LAND OFF WEST MOOR CROFT ROAD, GOLDTHORPE (PHASE 3)

**Additional Supplementary Ecological Information (SEI)
including Revised Biodiversity Net Gain (BNG) assessment of
land within New Park Springs**

Prepared for Gleeson Homes Limited

SLR Ref: 424.03044.00237
Version No: 1
September 2022

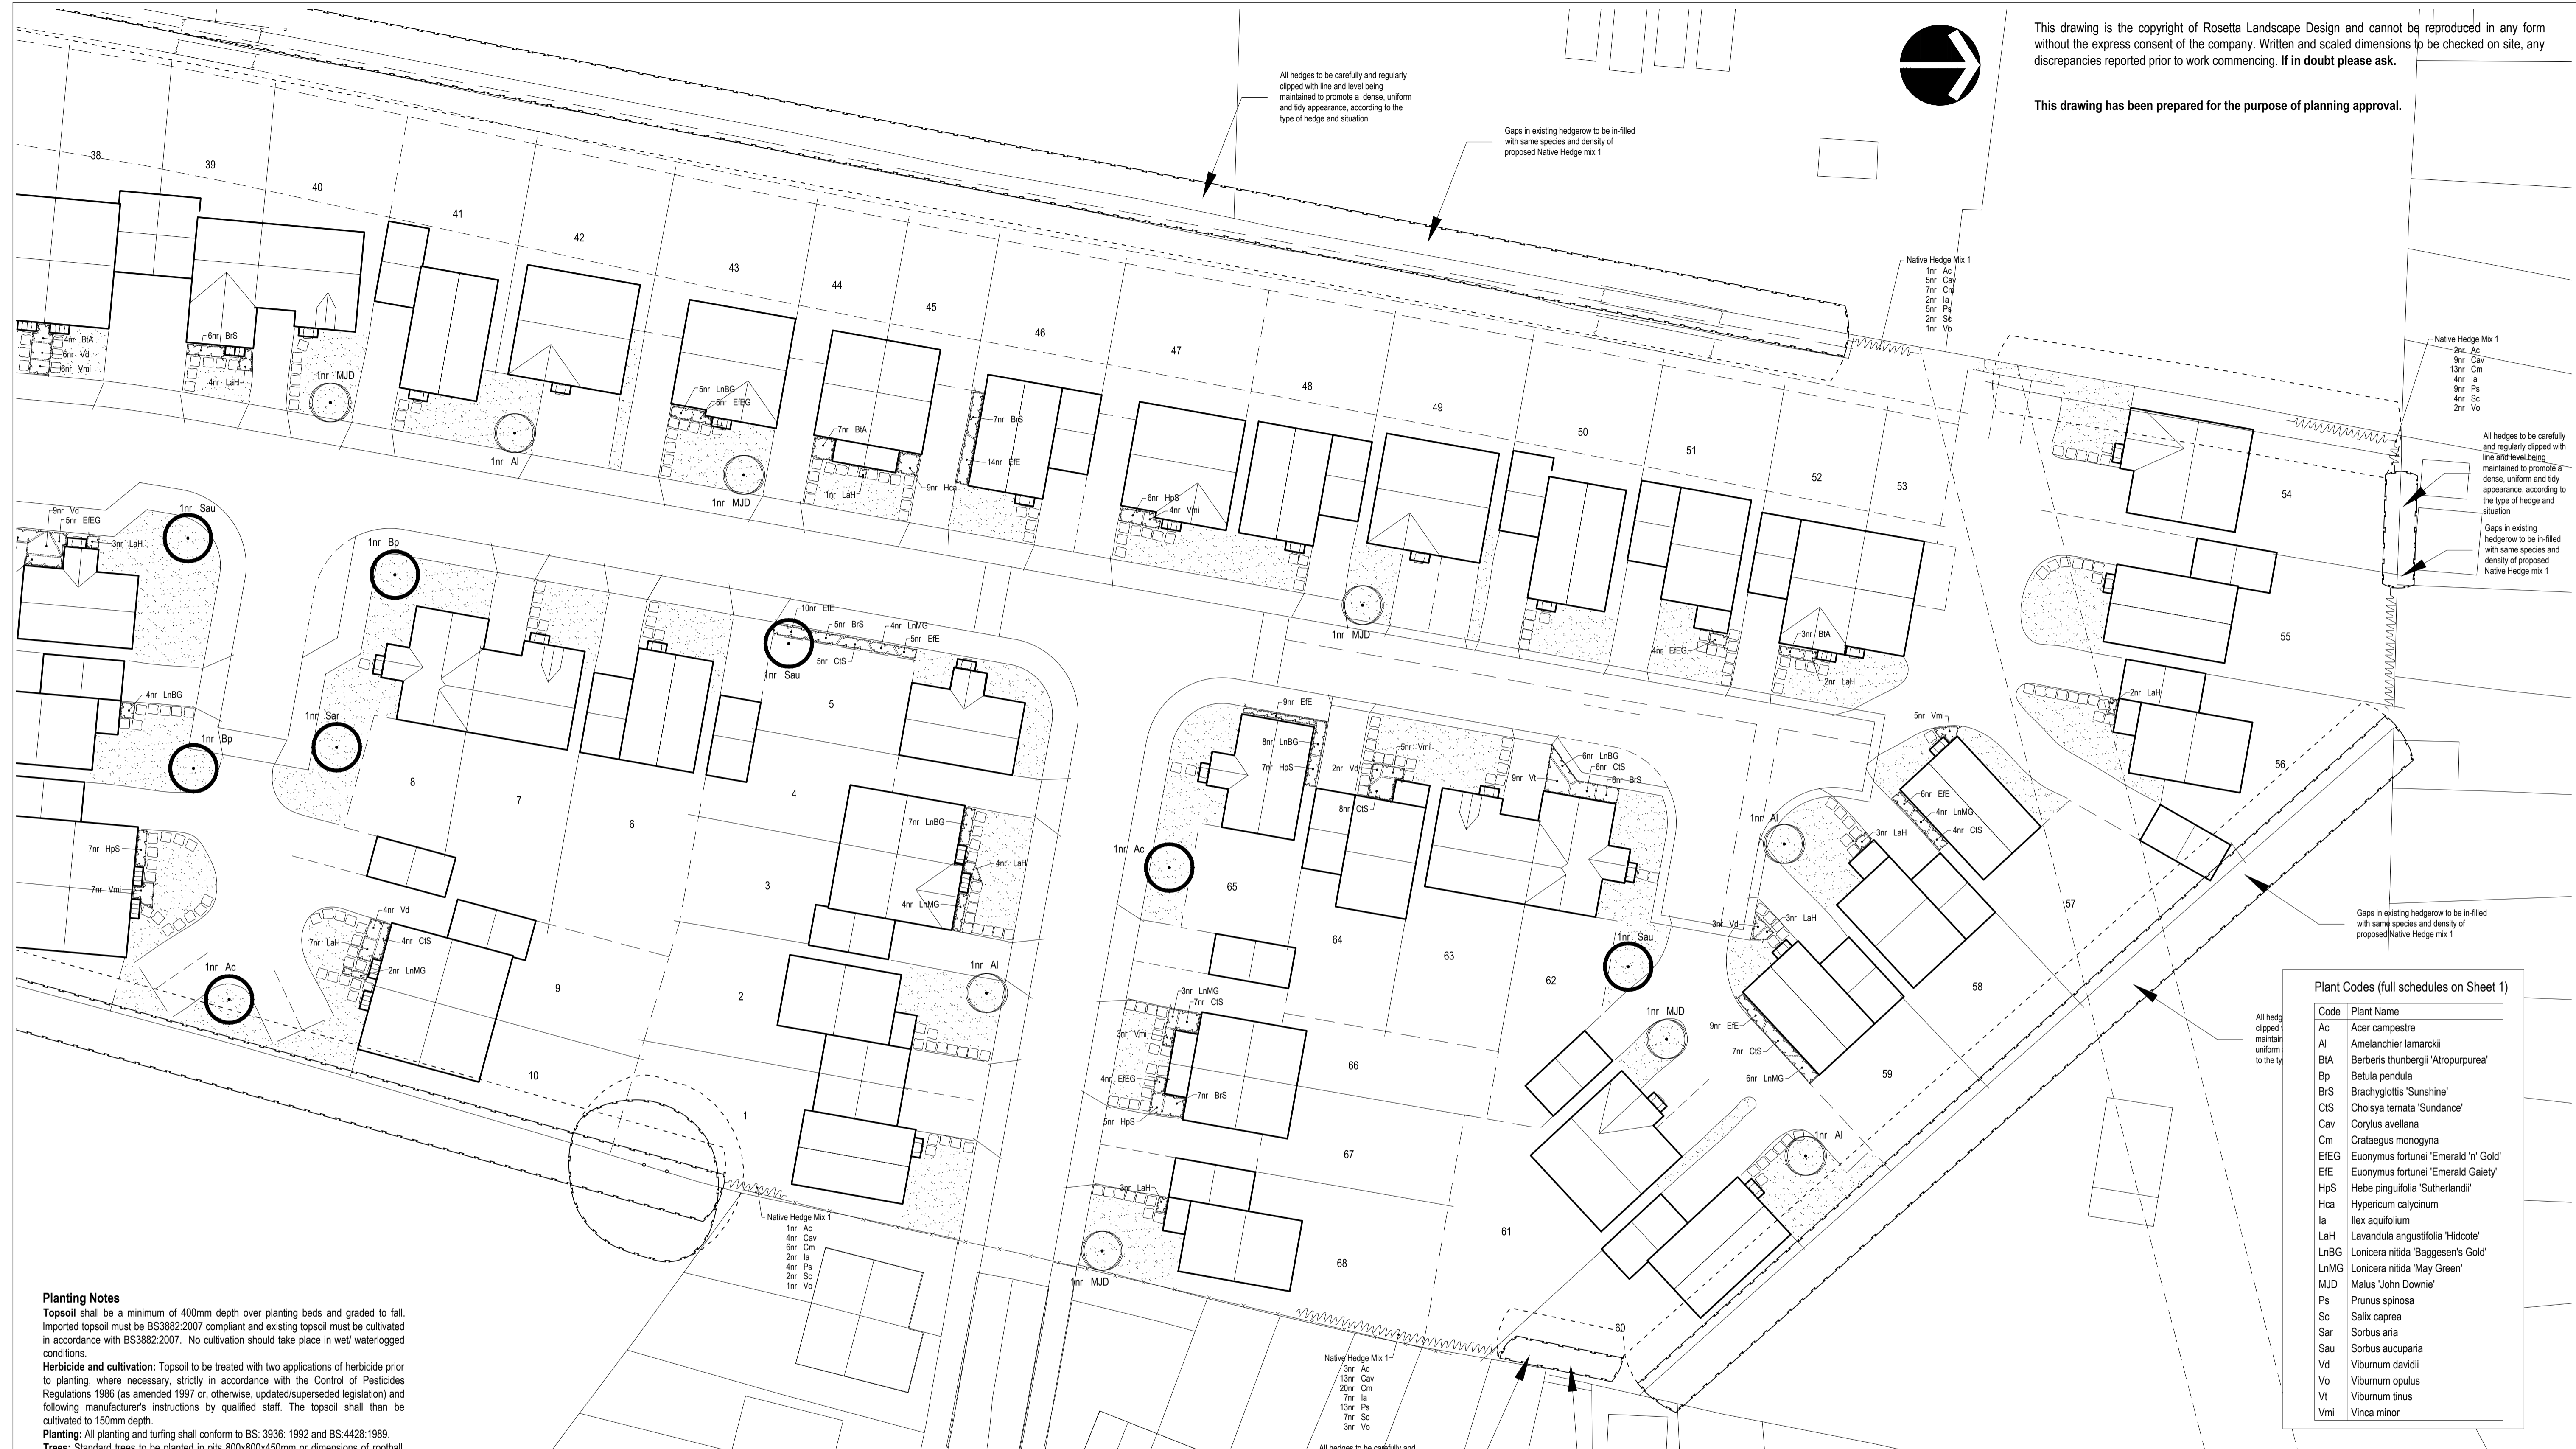
- The landscape proposals (Detailed Landscape Proposal (2 of 2) drawing no. 3627/3) show retained hedgerows on site. The metric sets out that all lengths of hedgerow will be retained on site; however, the landscape proposals appear to show a section of hedgerow to the north-western corner of the site to be removed. This should be confirmed and if proposed for removal, the metric should be amended accordingly.

As stated by Ms Lawrence, a section of hedgerow in the north-western corner of the Site is shown within the Landscape drawings as being removed⁴. The total length of hedgerow to be removed here is approximately 45 metres, and the Metric 3.1 assessment has been adjusted to reflect this (see entry for Hedgerow H4).

Proposals to plant 130m of new native species-rich hedgerow, as described within the previous SEI report and the original EclA report, shall deliver an overall net increase of over 27% of hedgerow units.
